Date: 08 December 2020  
Our ref: 334078  
Your ref: 3/2020/0667

**Planning consultation: Change of use and conversion of former fish hatchery to three holiday let units and creation of associated car park for six vehicles.  
Location: Whitcher Well Fish Hatchery Whitendale Road Dunsop Bridge BB7 3BL**

#### **SUMMARY OF NATURAL ENGLAND'S ADVICE**

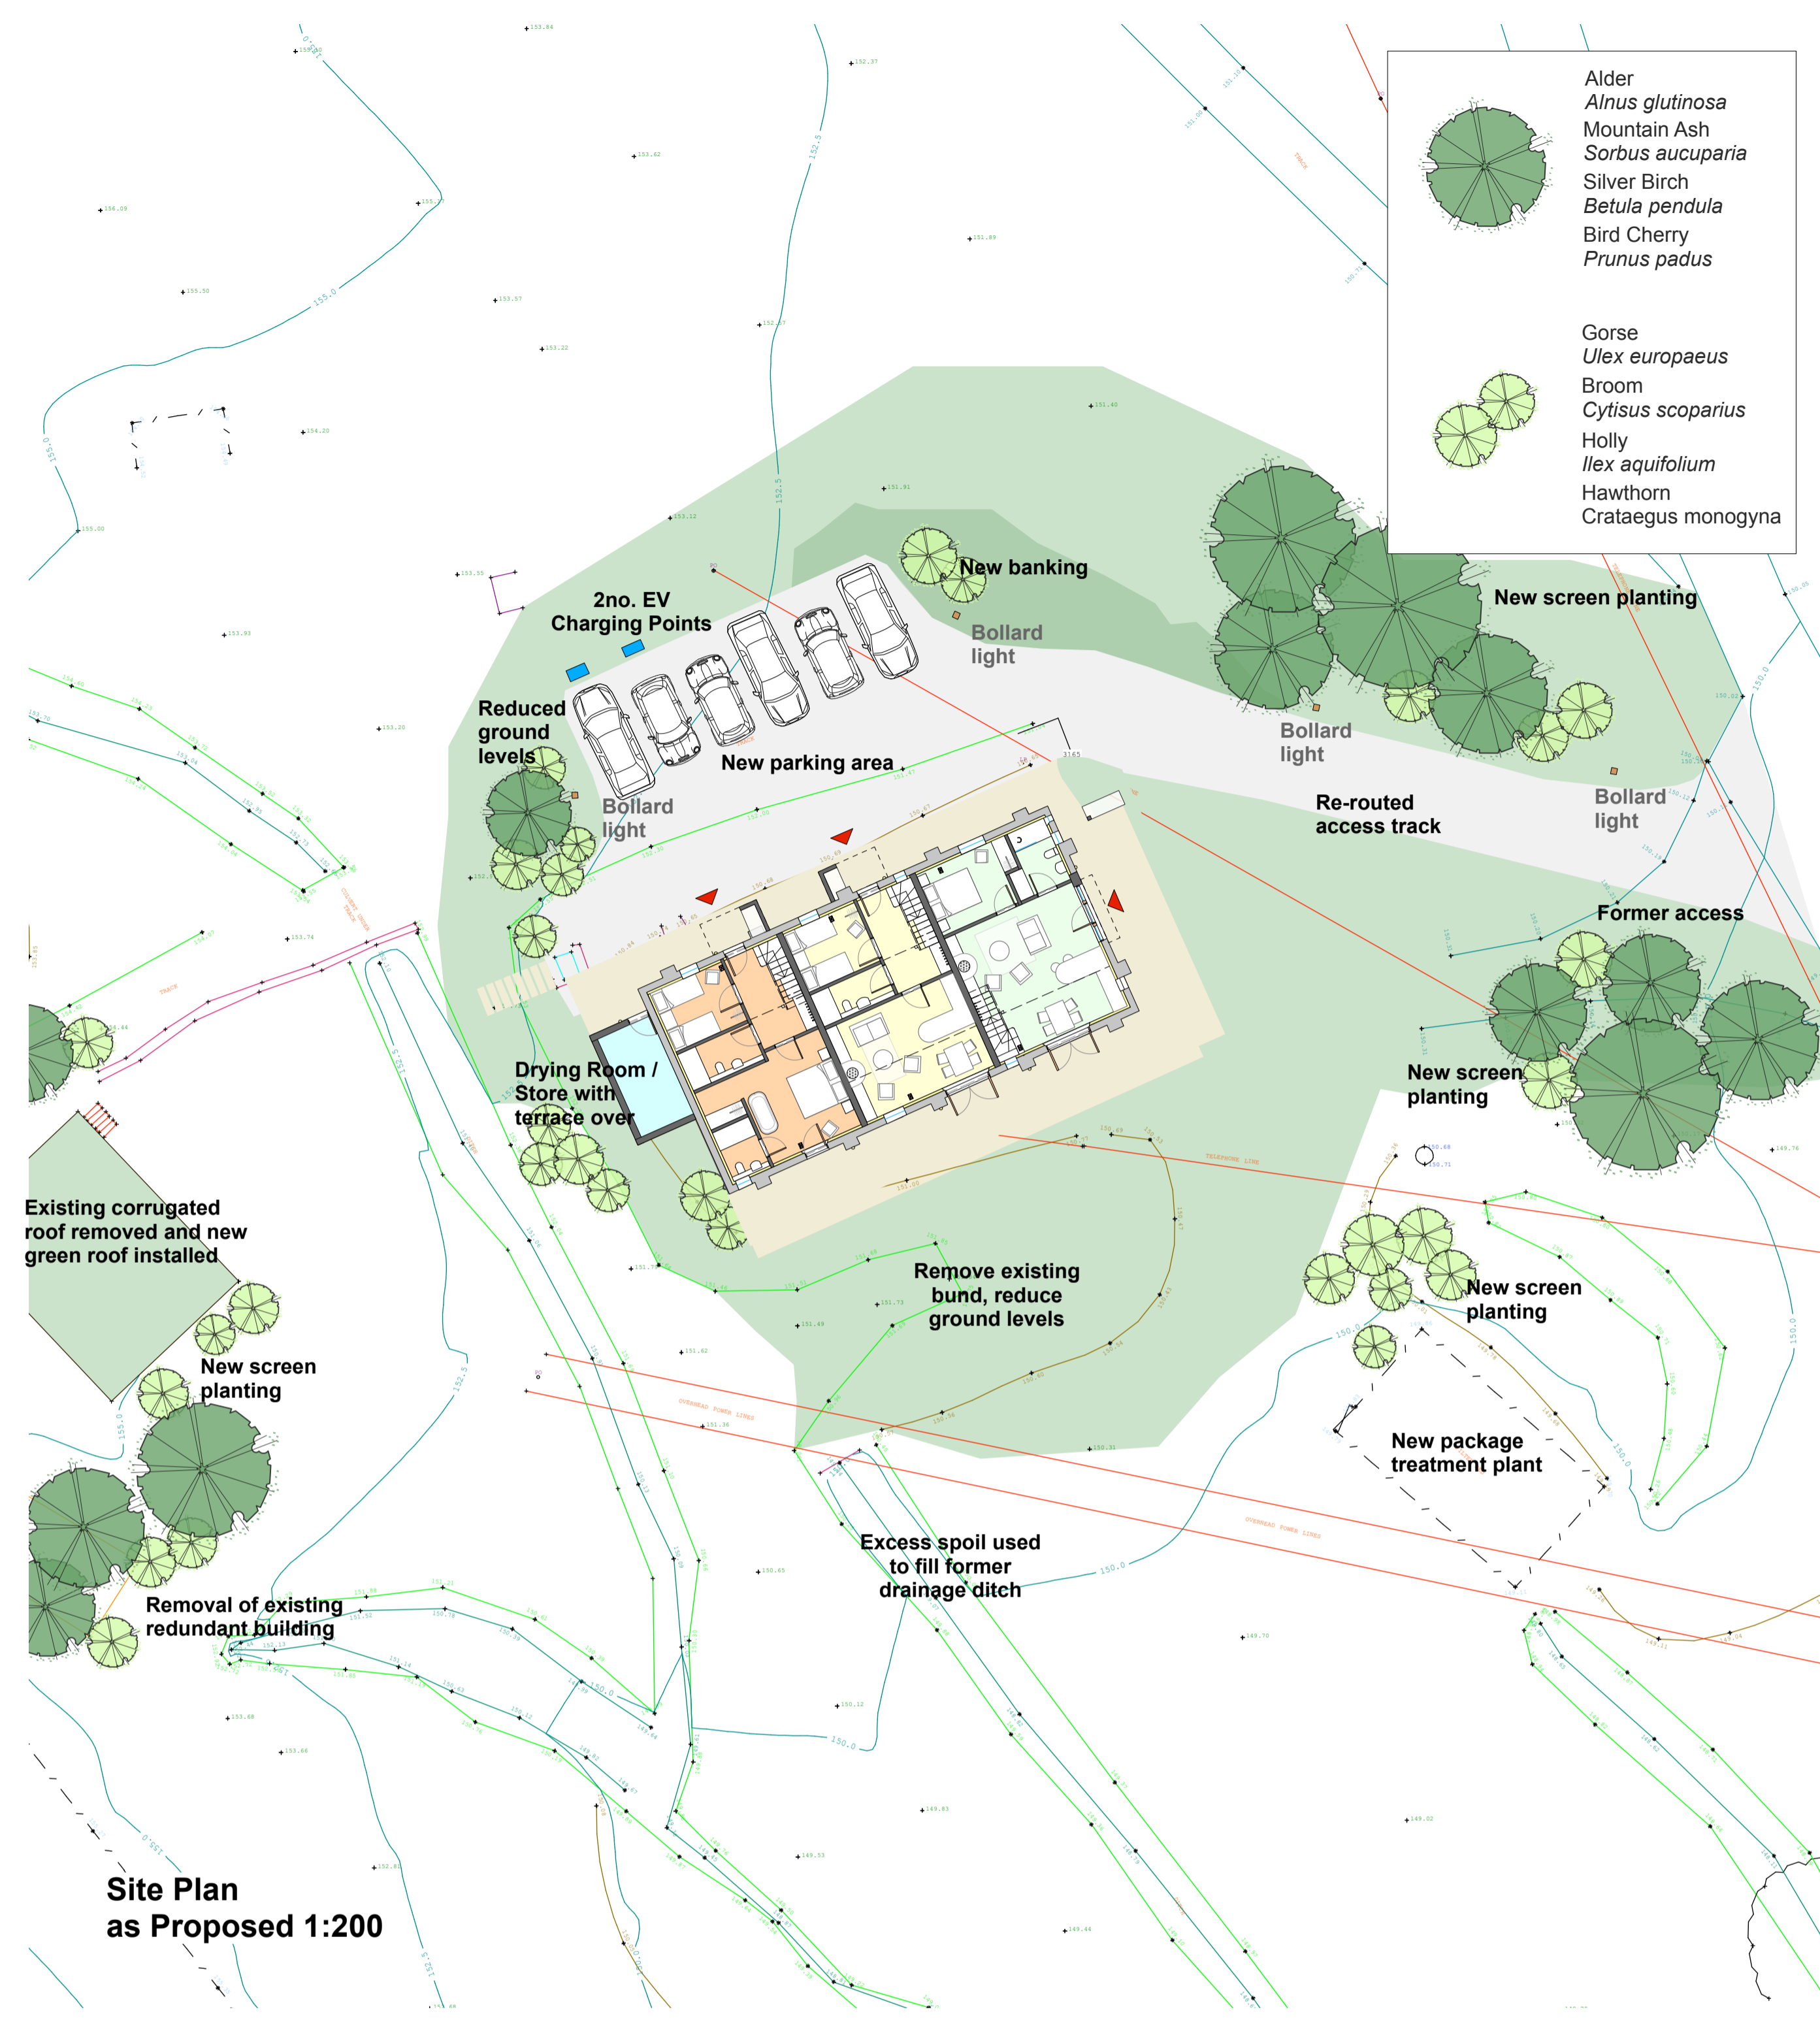
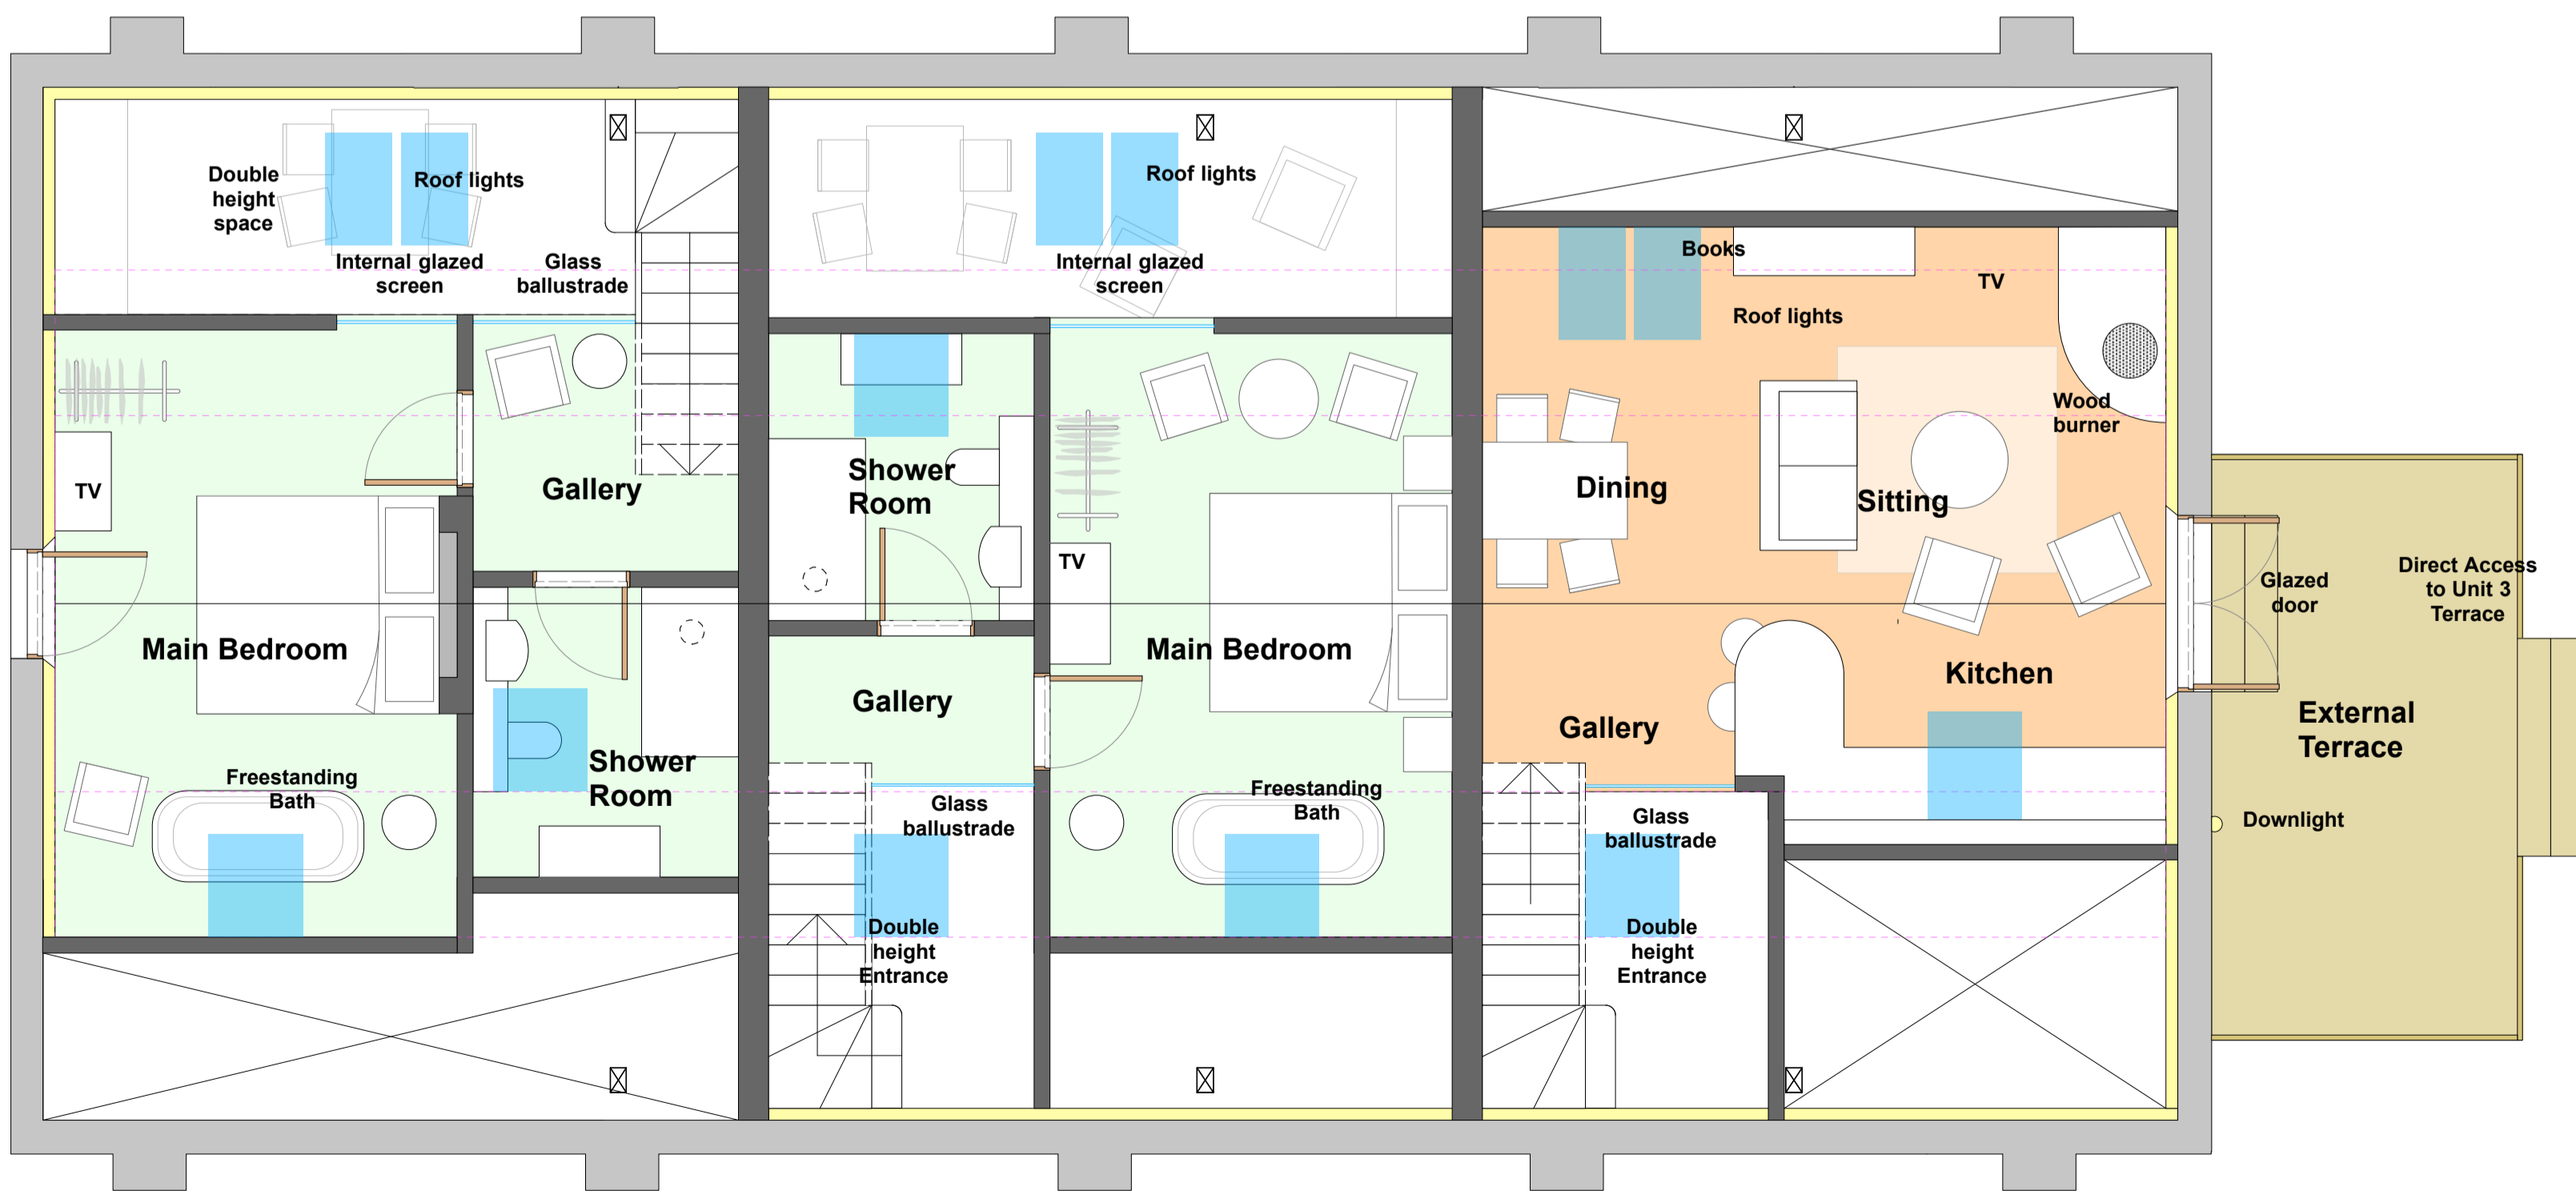
Detailed plans need to be submitted to show the proposed planting and how this will help to mitigate the landscape impacts along with site sections showing the impact of the proposed land lowering.

There is also a lack of assessment of the impact of the design features such as the external terrace, lighting and porch additions on the special qualities of the AONB.

We also note that the proposed site plan and floor plans (drawing no. 5891c/b/01, April-20) indicates works to an existing building on the west of the site but it is not clear what is proposed. It is marked on the plan as 'existing corrugated roof removed and green roof installed'. Please clarify what this building will be used for.
